Our Ref: M/11/12/NMA-JAC

**Application for a Non-Material Amendment following a grant of planning permission
M/41/11 for internal alterations and east elevation extended at ground floor only
1 Moraunt Drive, Middleton-on-Sea**

EAST ELEVATION.

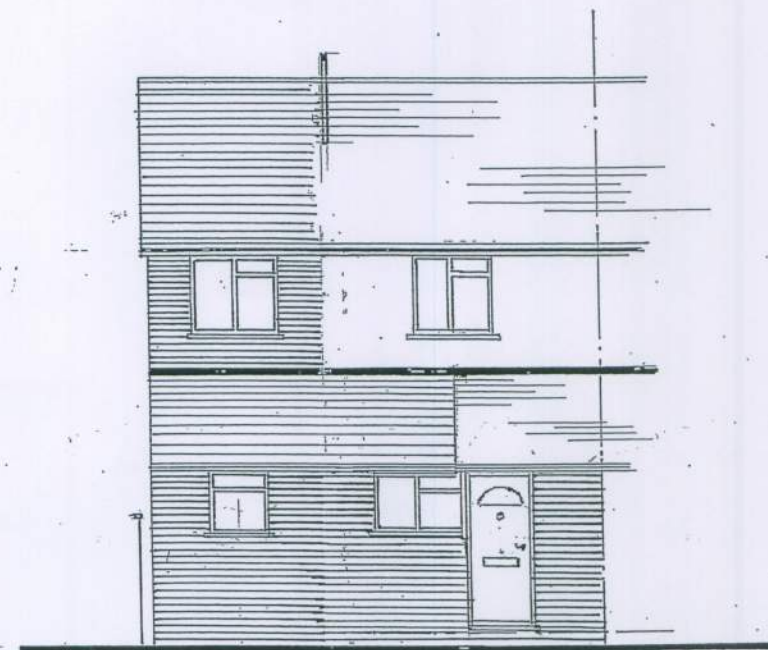
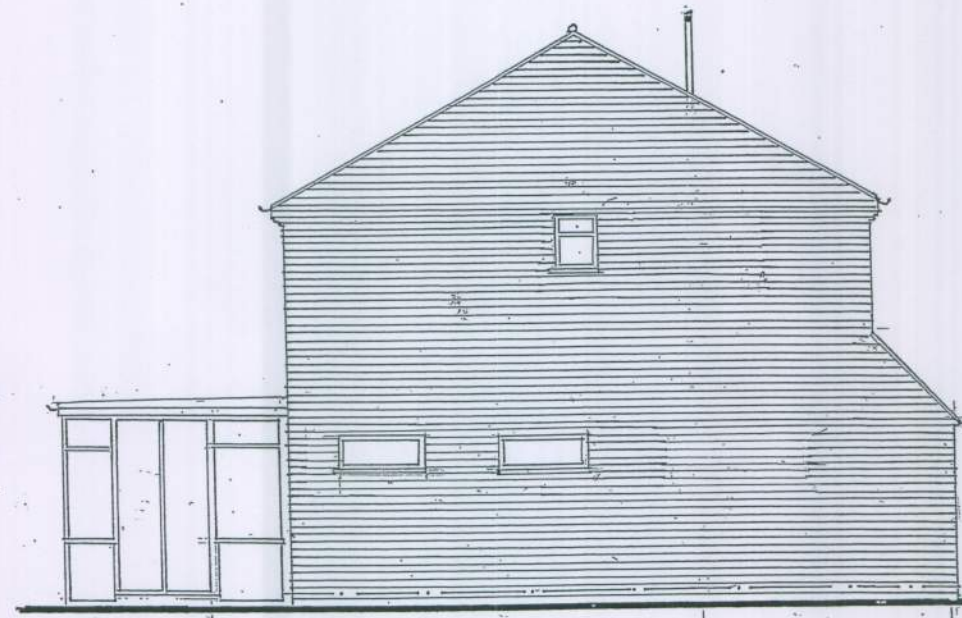
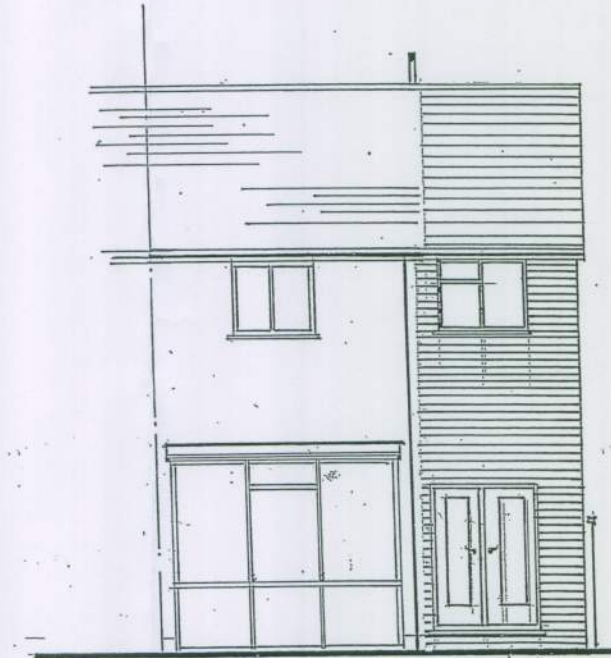
The extended area to the front east elevation cannot be accepted as a Non-Material Amendment to the approved planning permission M/41/11 and will require the submission of a new planning application.
